Subject: Pagham responses

At a meeting of its Planning Committee held on 30th May 2017, Pagham Parish Council considered the following application(s):

P/41/17/HH – 78 Pagham Road, Nyetimber PO21 4NL – demolition of existing single storey side and rear extensions and erection of two storey rear extension.

NEW FIRST FLOOR PLAN

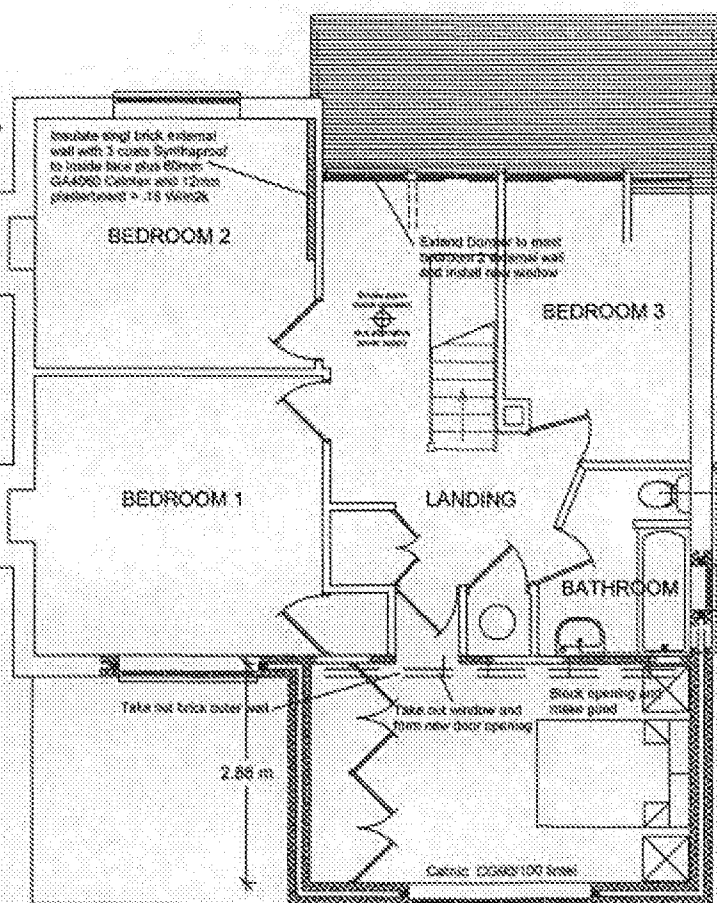
RESOLVED: NO OBJECTIONS provided obscured glazing is used in the bathroom window.
